From: David Fuller [REDACTED]
Sent: 01 June 2015 09:53
To: Ross Leal
Cc: AFA Fuller
Subject: K/17/15/HH - Russet House, Gorse Avenue, Kingston Gorse

Further to our discussion on Friday (29th), please see below responses below addressing the concerns raised in a letter dated the 19th May (attached) from Mr & Mrs Millet, the immediate neighbours at Scesaplana to the East of Russet House.

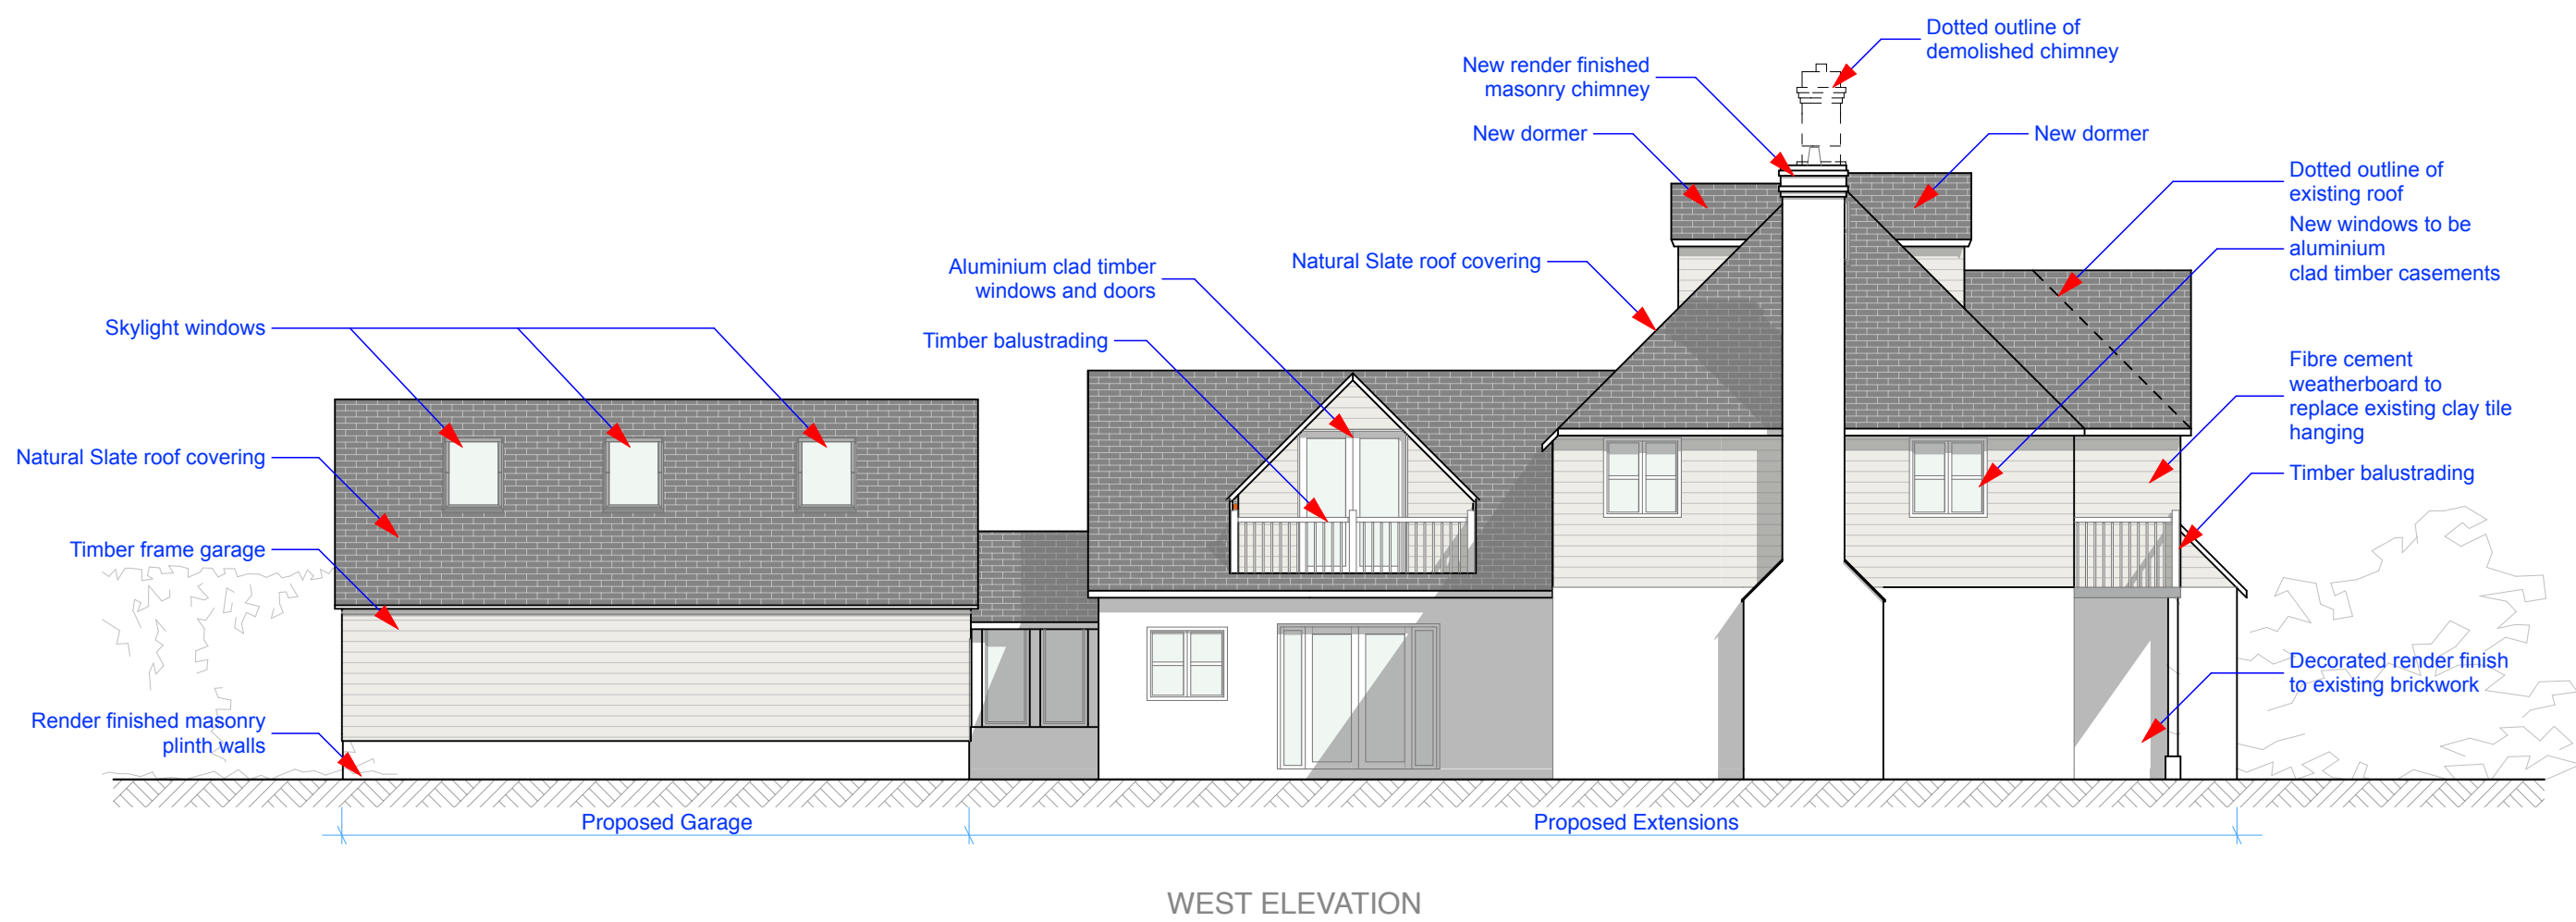
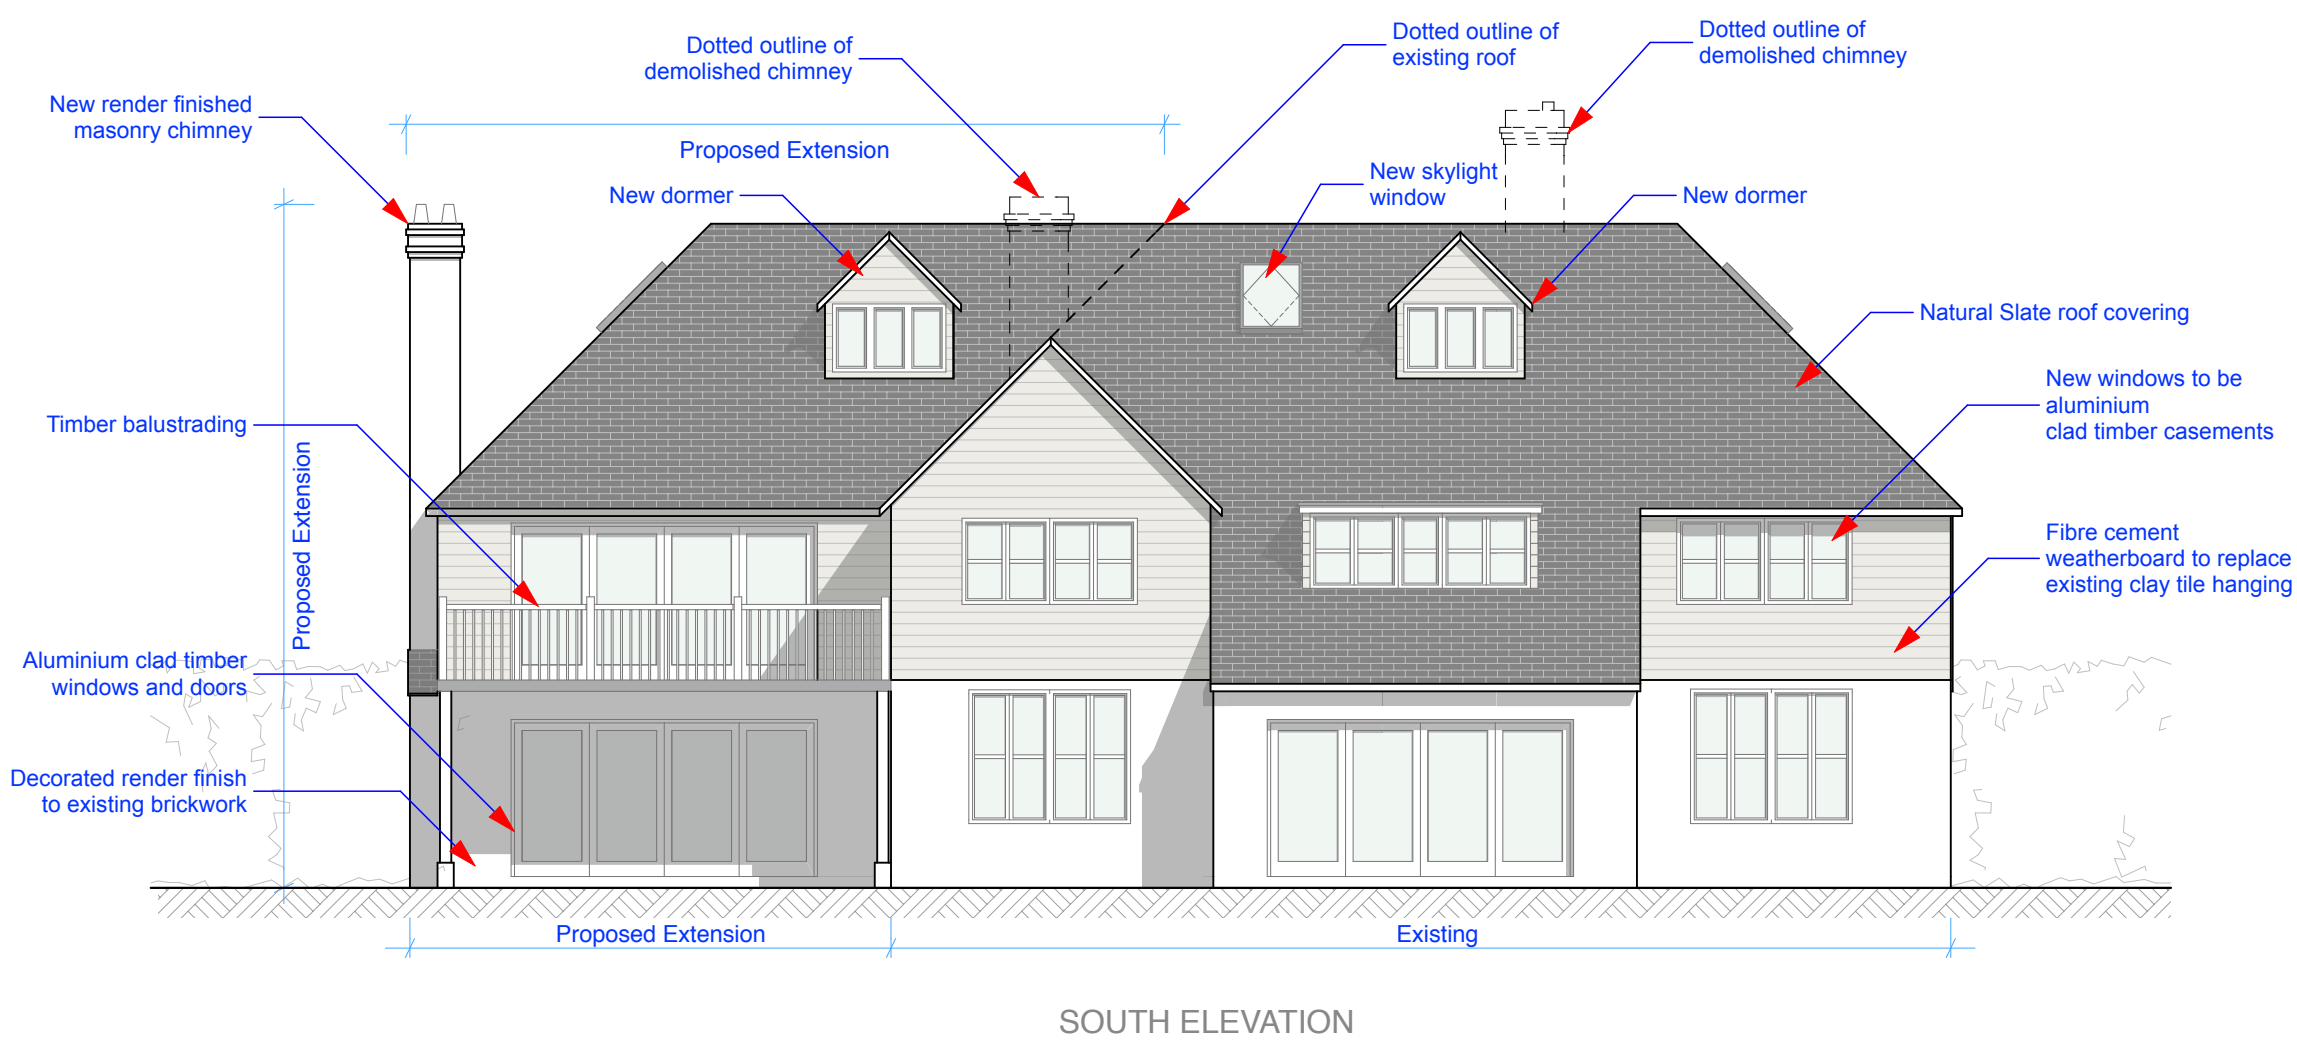
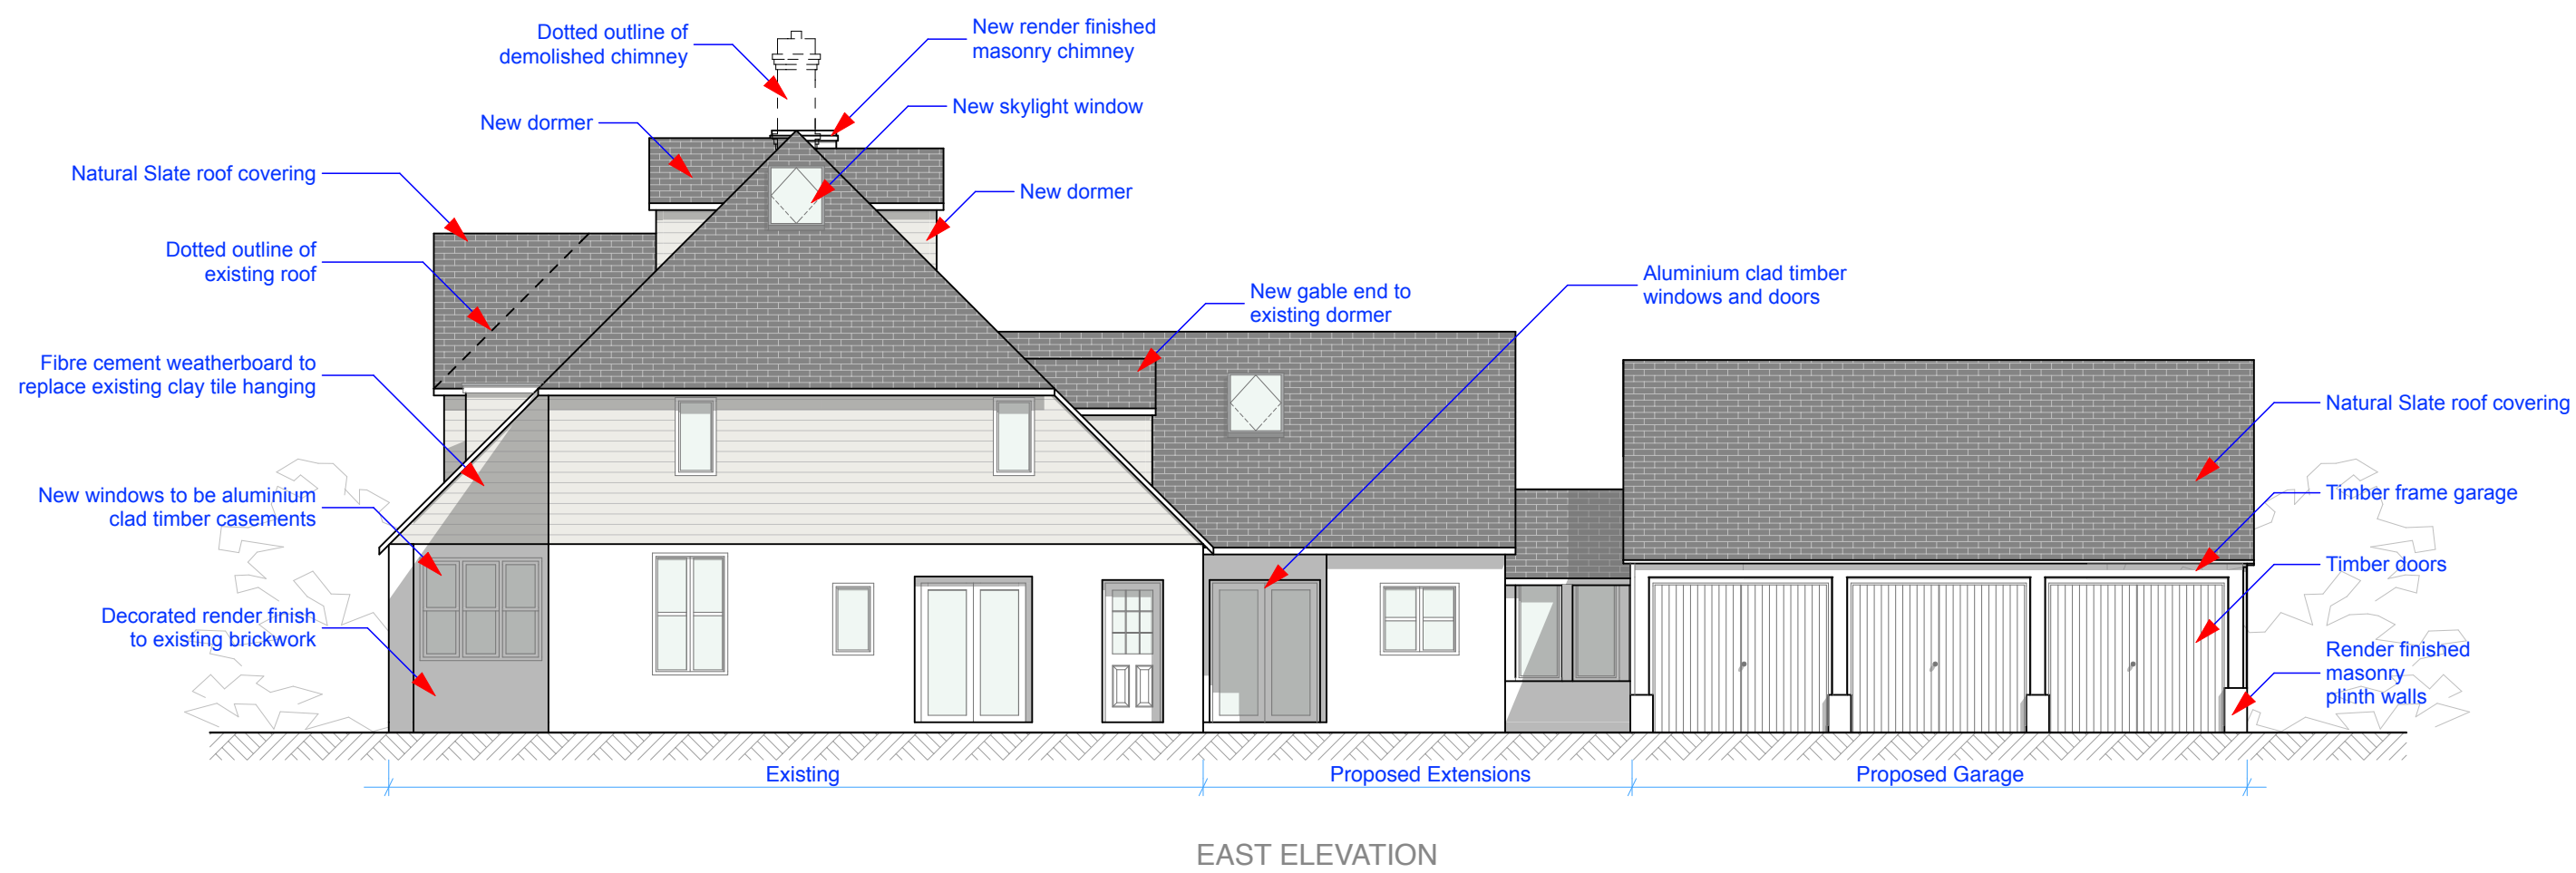
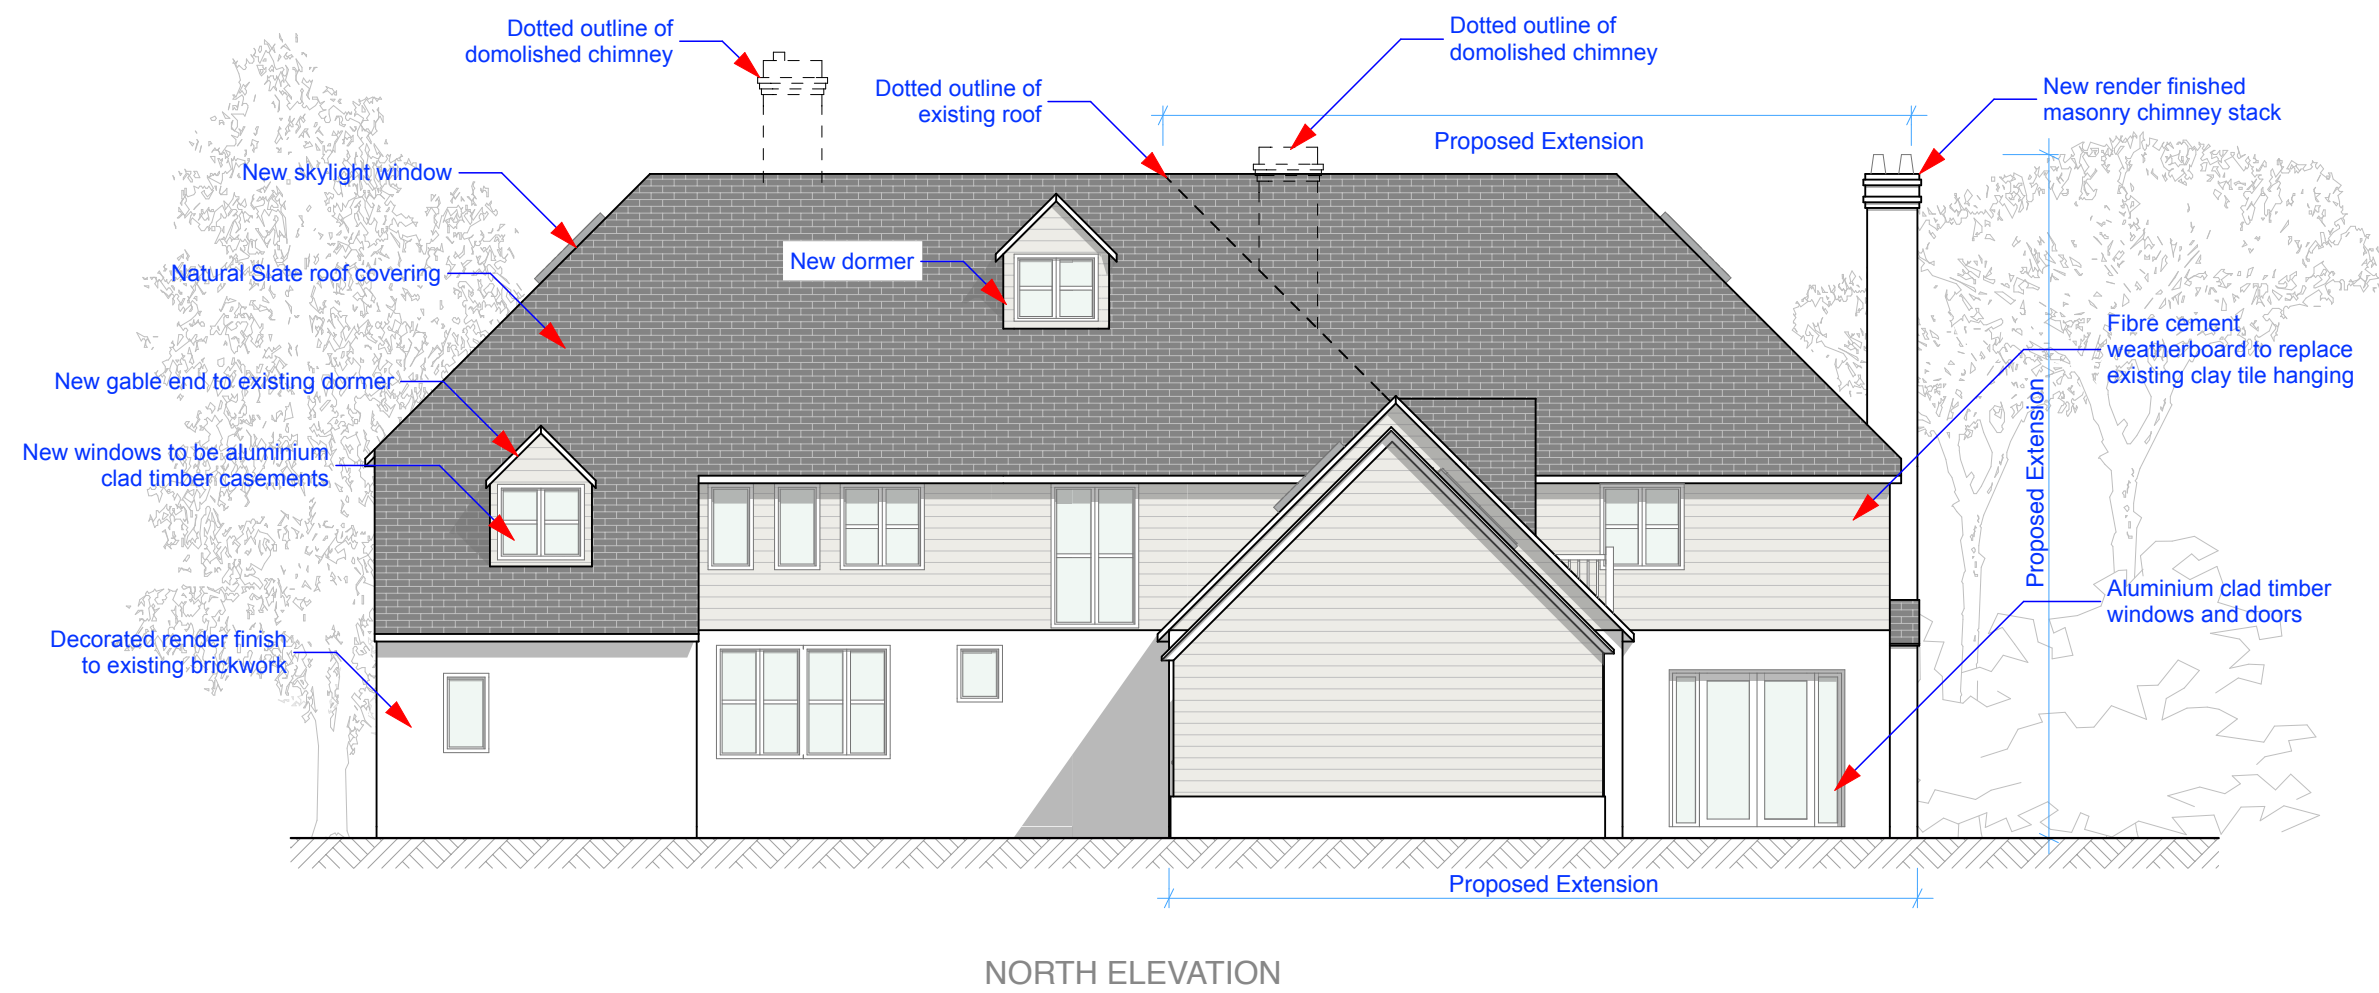
2. The scale of the rear extension (northside) is very large with a large blank wall and high roof. The visual sight could be very ugly especially if all existing greenery, trees and hedging is removed. It would be more appropriate if it was reduced in length and height. The need for three garages indicates there will be more traffic. The driveway and entrance to the garages and the increase of traffic as a result will mean the entrances would be more prone to accidents on this very narrow road.

2) The massing of the Garage building and corresponding roof shapes are to be subservient to the host dwelling, in an attempt to minimise the impact visually to the surrounding properties, whilst creating adequate habitable space internally. The proposed Garage is to provide 2 parking spaces only, and does not increase the parking provision from that of the existing dilapidated Garage. The proposed Garage seeks to provide an aesthetically enhanced building in shape and form, from that of the existing unsightly flat roofed building, by utilising a pitched roof with Sussex Barn Ends. Furthermore this is a family dwelling and is to be used as such, and therefore we feel there would be no exacerbation of accident risk in Downsview Road. There are also mature hedges of considerable height on Russet House's Eastern boundary, which means that much of the garage building will not be visible from Downsview Road.
